ASSESSMENT REPORT

MIXED USE DEVELOPMENT, EASTLAKES SHOPPING CENTRE MP 09_0146 MOD 2

DRAWING TITLE
**CONSTRUCTION PLATFORM
VEHICLE TURNING PATH**

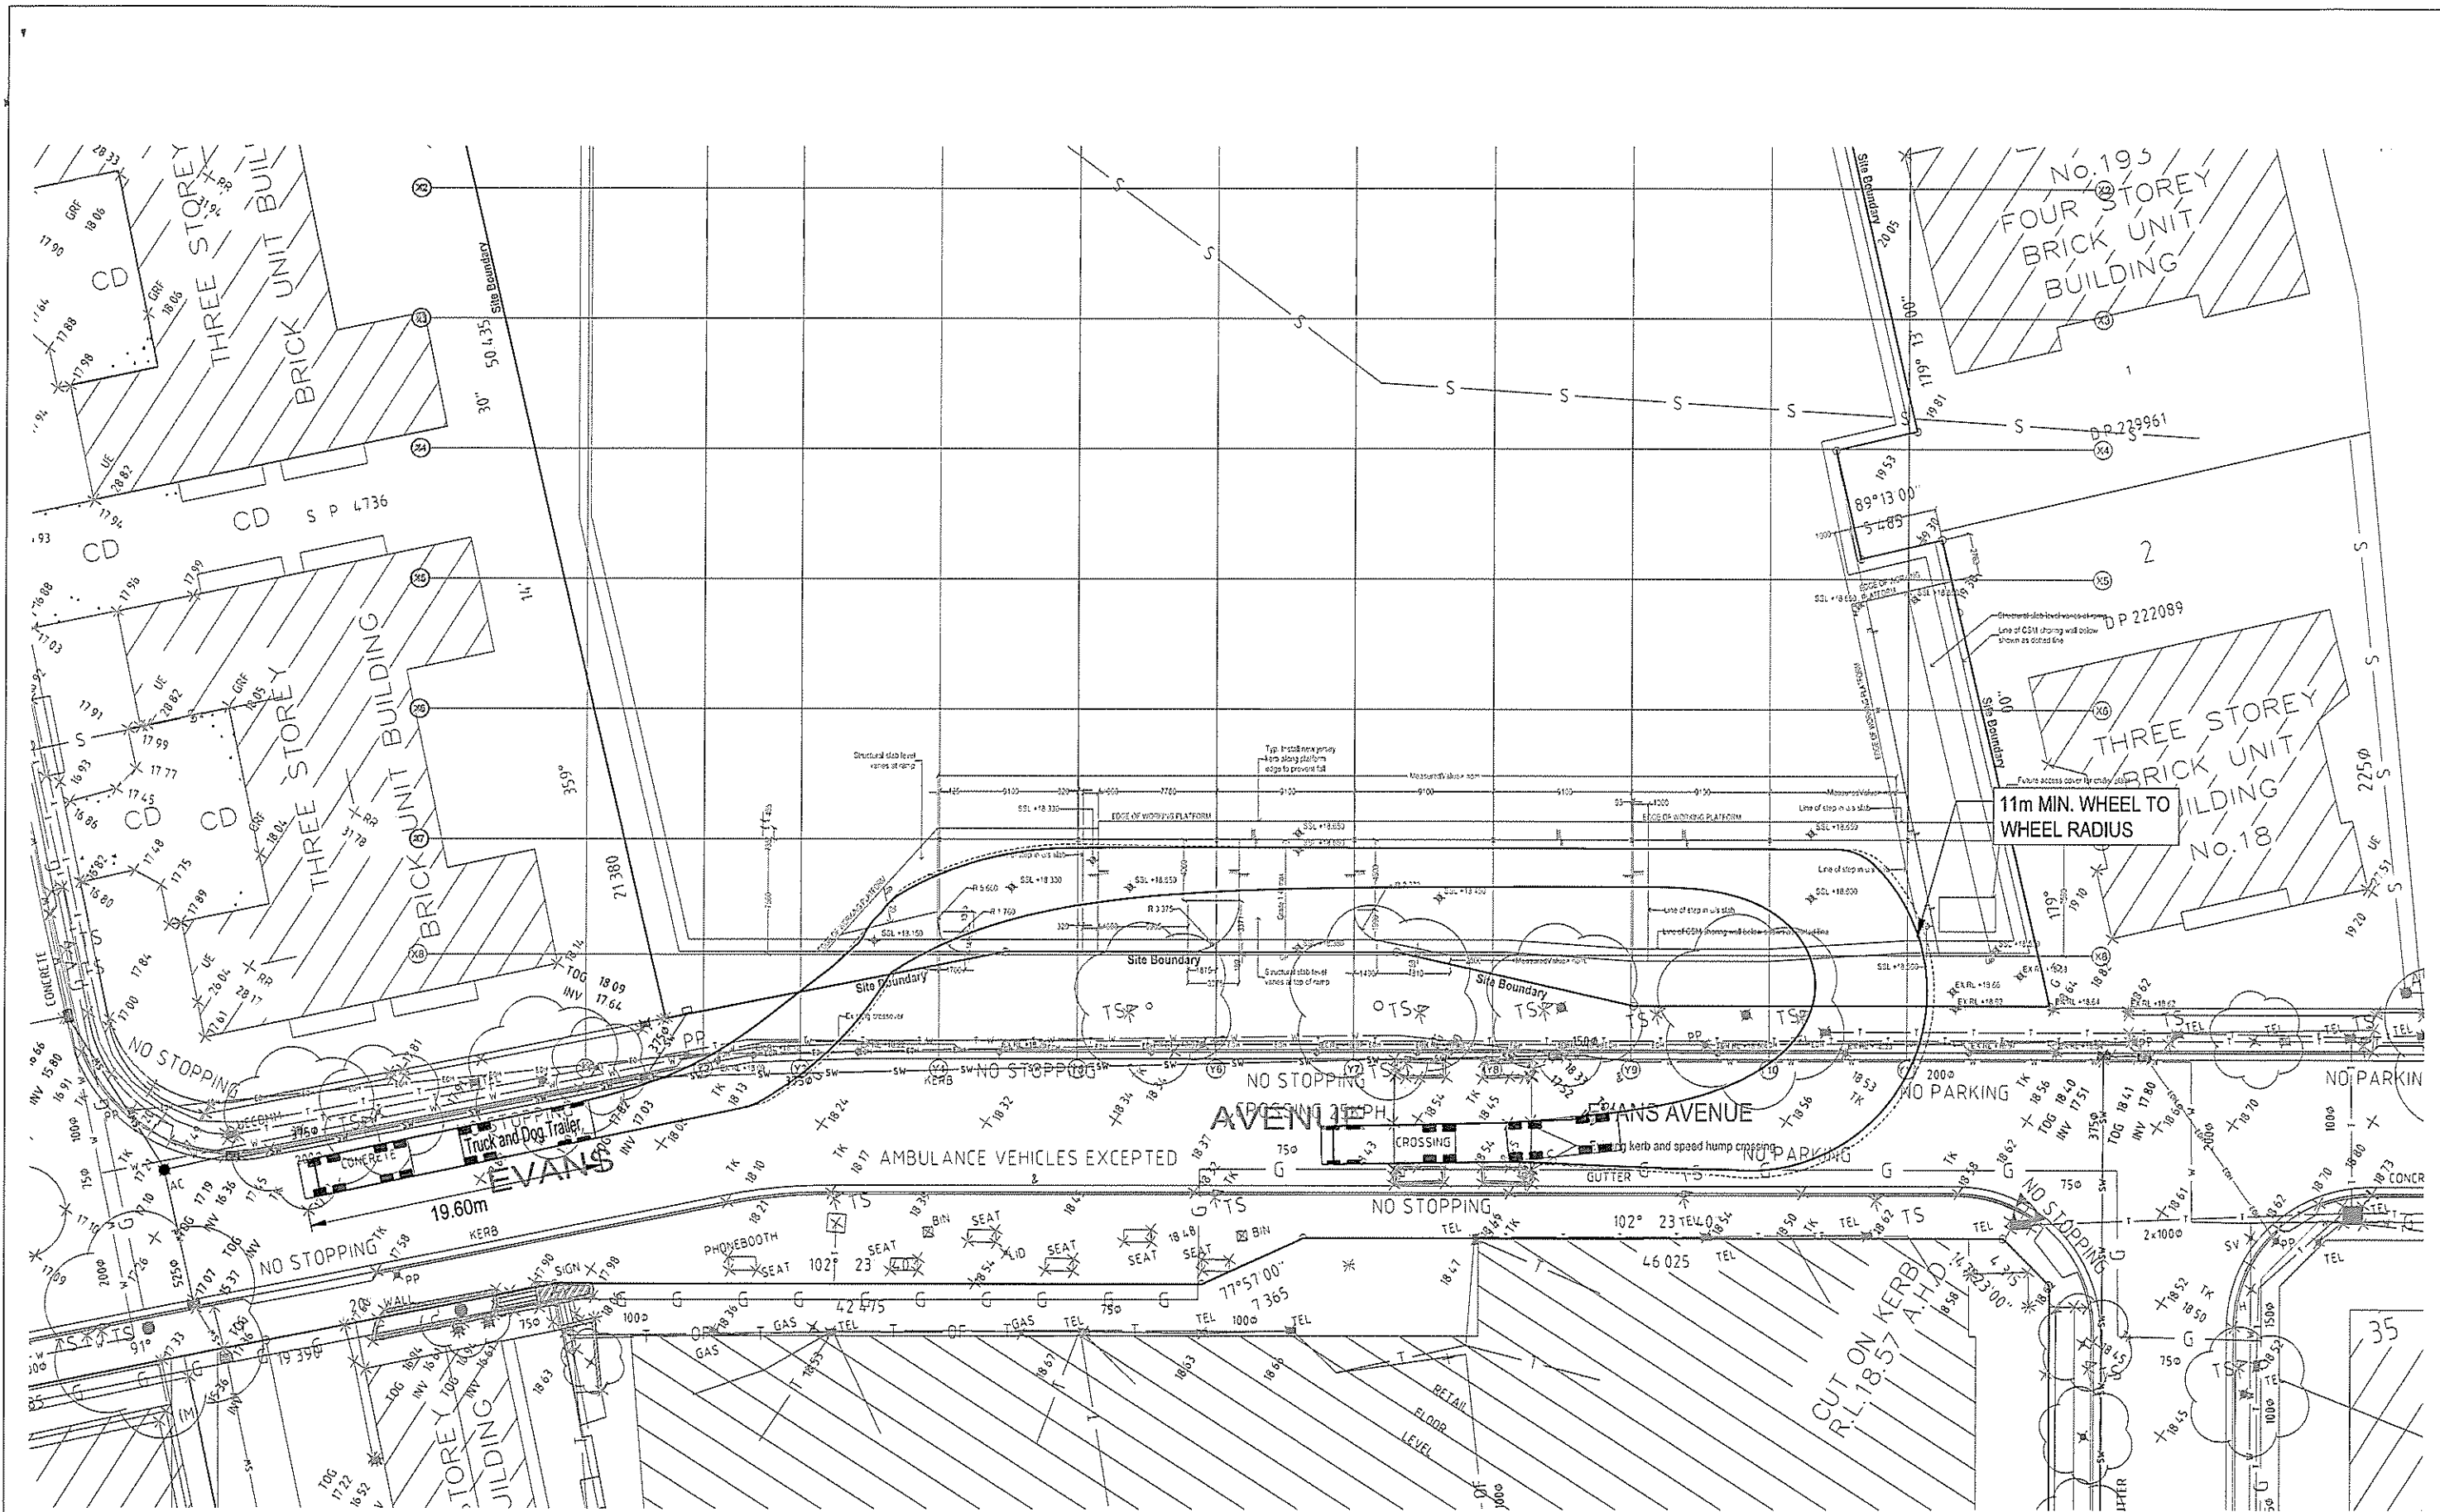
Council requested an additional swept path analysis for the Gardeners Road and Racecourse Place intersection and the Racecourse Place and Evans Avenue intersection. It also requested an investigation into the existing road pavement adequacy to cater for the largest proposed vehicles and design and reconstruction of the road pavement for the travel route in accordance with Austroads.

In response to Council's comments, the Proponent provided an additional swept path analysis for the intersections requested and design calculations in accordance with Austroads – Guide to Pavement Technology Part 2: Pavement Structural Design, 2012 showing the existing road pavement can cater for the 19 m long vehicles.

Council reviewed the analysis and advised it has no further comments regarding swept paths. However, it requested a dilapidation report be provided for all traffic facilities along Racecourse Place and Evans Avenue.
